# CITY OF ALBUQUERQUE

January 30, 2020

**Re: Starbuck Drive-Thru**  
**1314 Gibson Blvd. SE Albuquerque NM 87106**  
**Traffic Circulation Layout**  
Engineer's/Architect's Stamp 01-16-20 (L15D041)

TRAFFIC CIRCULATION LAYOUT
APPROVED

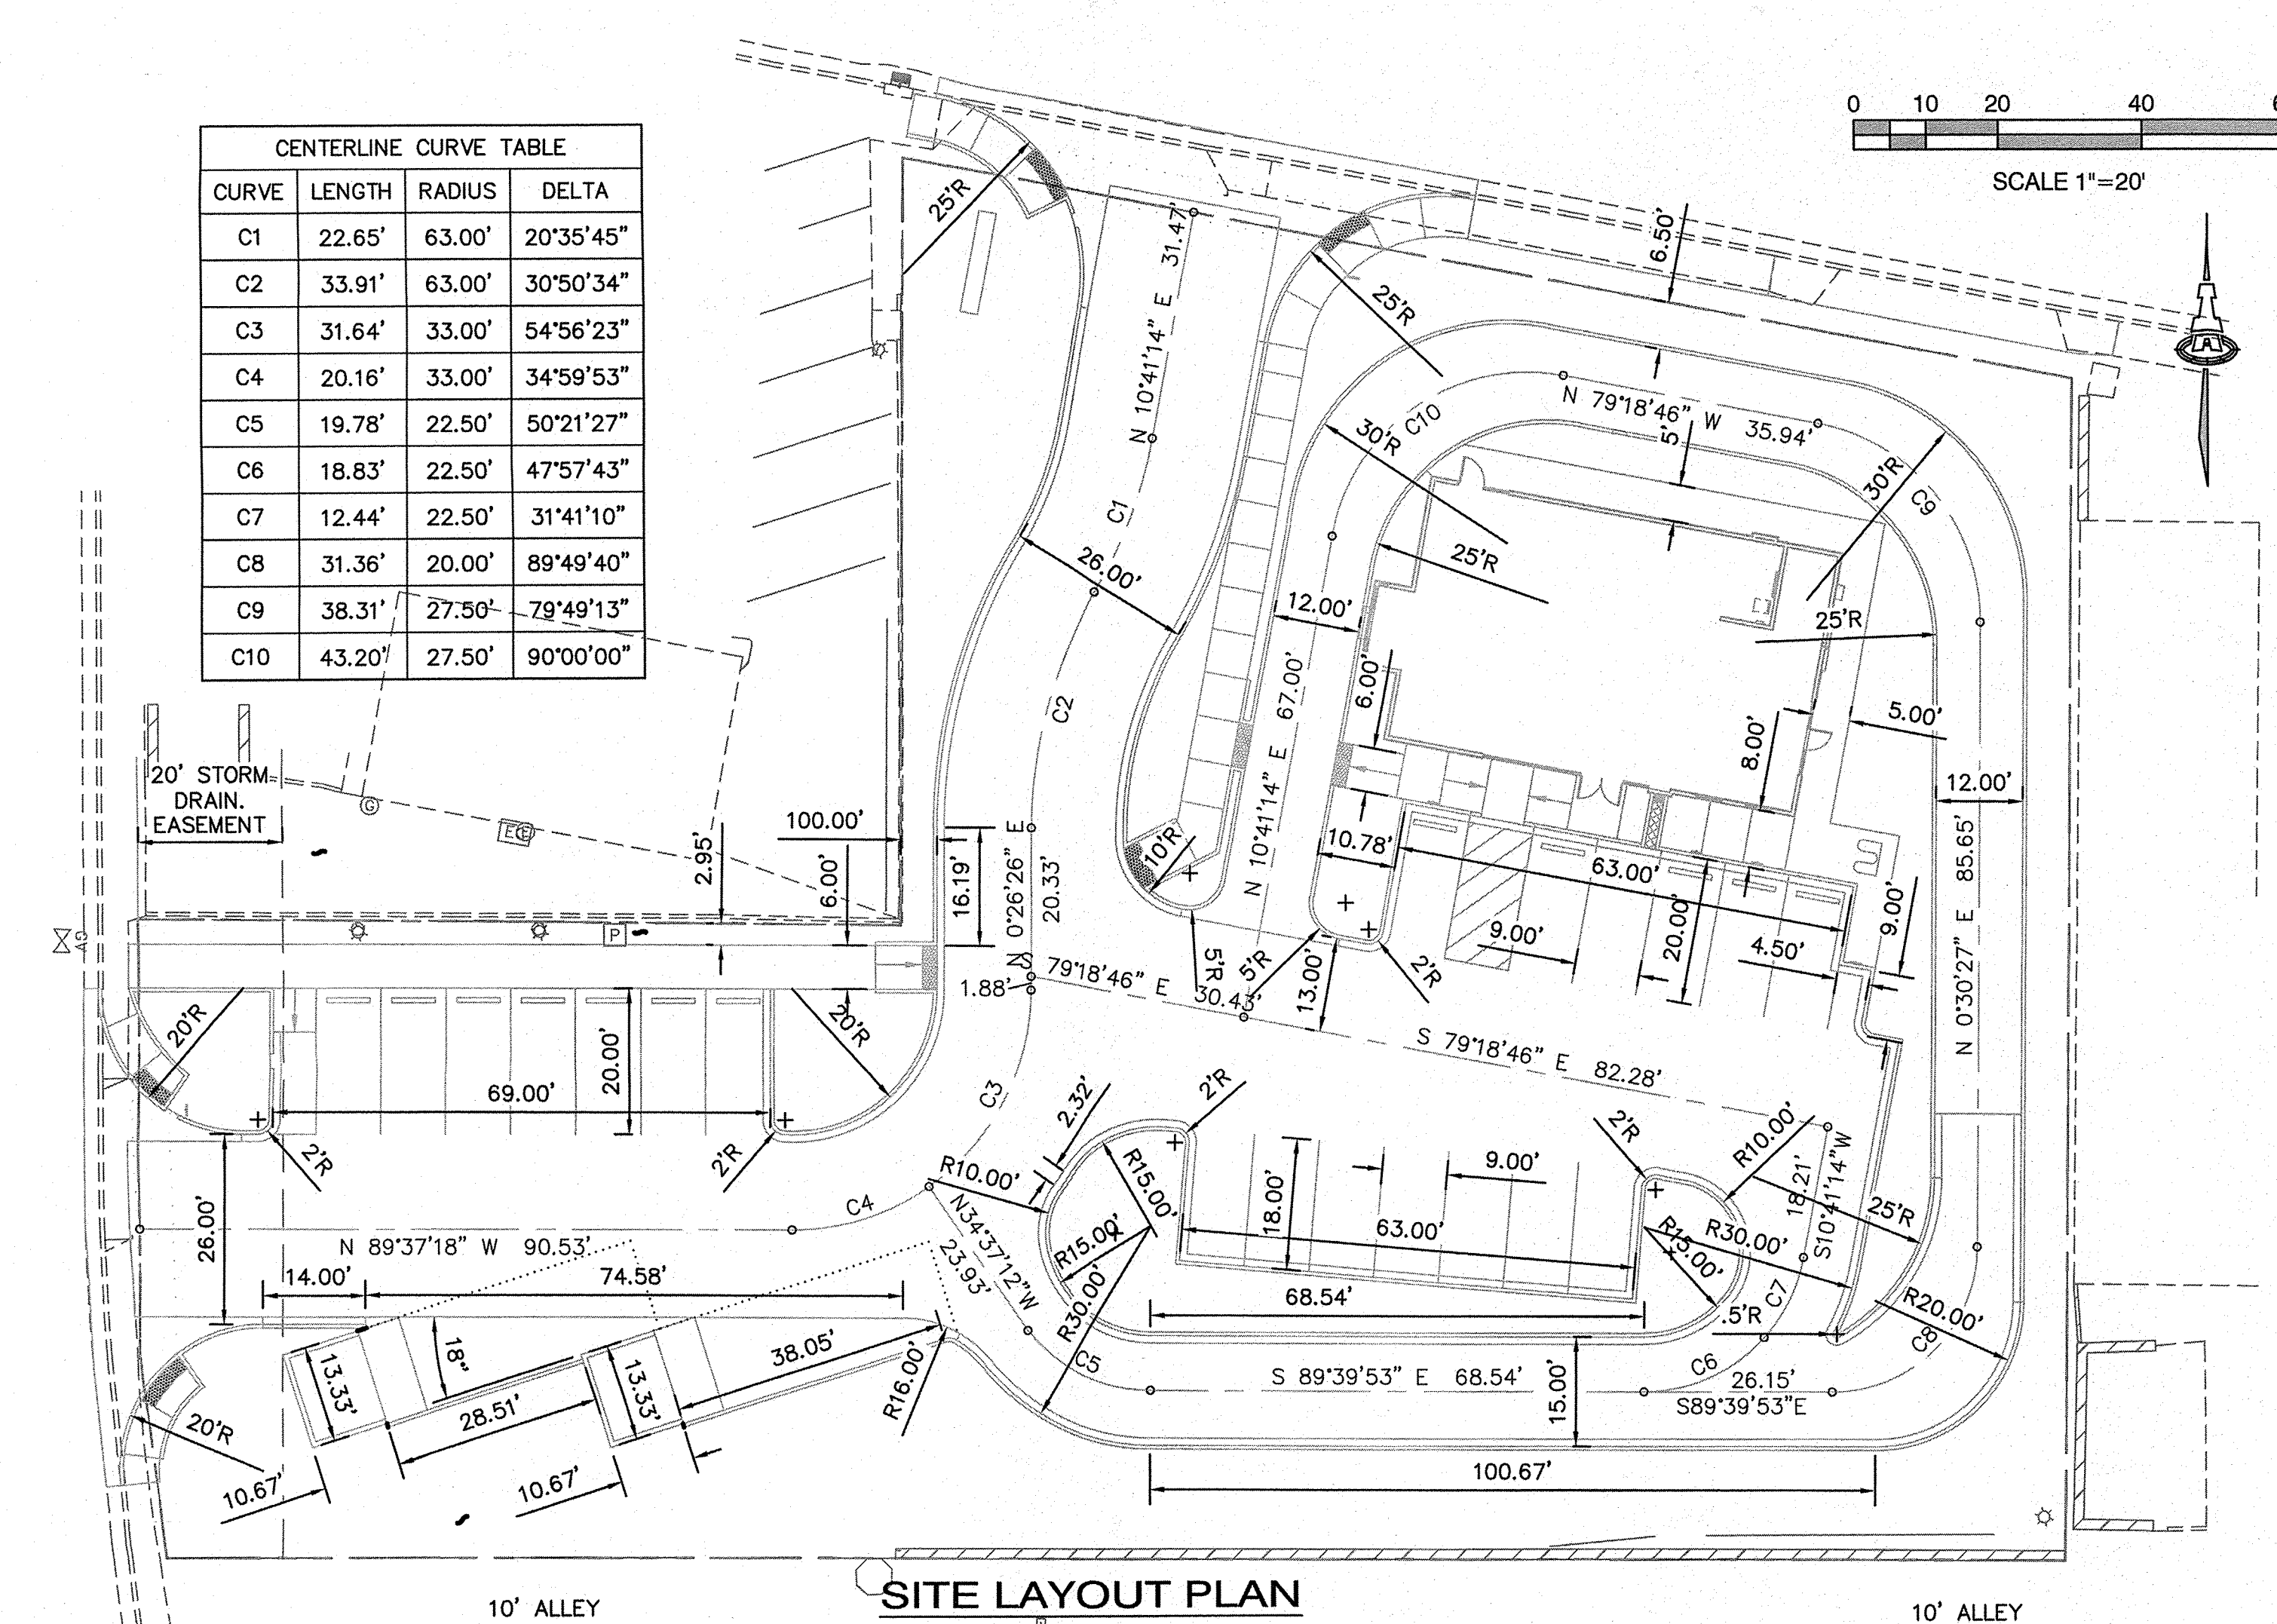
1. Please show a vicinity map showing the location of the development in relation to streets and well known landmarks.
2. List the number of parking spaces required by the zoning code as well as the proposed number of parking spaces including bicycle and motorcycle parking.

3. The ADA accessible parking sign must have the required language per 66-7-352.4C NMSA 1978 **"Violators Are Subject to a Fine and/or Towing."** **Please call out detail and location of signs.**

4. Please show the bike rack detail.
5. Refuse vehicle maneuvering shall be contained on-site. The refuse vehicle shall not back into the public right of way.; **provide a copy of refuse approval.**

6. It is not apparent what type of pavement surface is being proposed. A hard driving surface will be required as part of this proposed project for parking area and drive aisles.

7. All one-way drives shall have **"One Way"** and **"Do Not Enter"** signage and pavement markings. Please show detail and location of posted signs and striping.

8. Show the clear sight triangle and add the following note to the plan:  
"Landscaping and signage will not interfere with clear sight requirements. Therefore, signs, walls, trees, and shrubbery between 3 and 8 feet tall (as measured from the gutter pan) will not be acceptable in the clear sight triangle.

9. Unused curb cuts must be replaced with sidewalk and curb & gutter. A build note must be provided referring to the appropriate City Standard drawing.

10. Add a note stating "All broken or cracked sidewalk must be replaced with sidewalk and curb & gutter." A build note must be provided referring to the appropriate City Standard drawing.
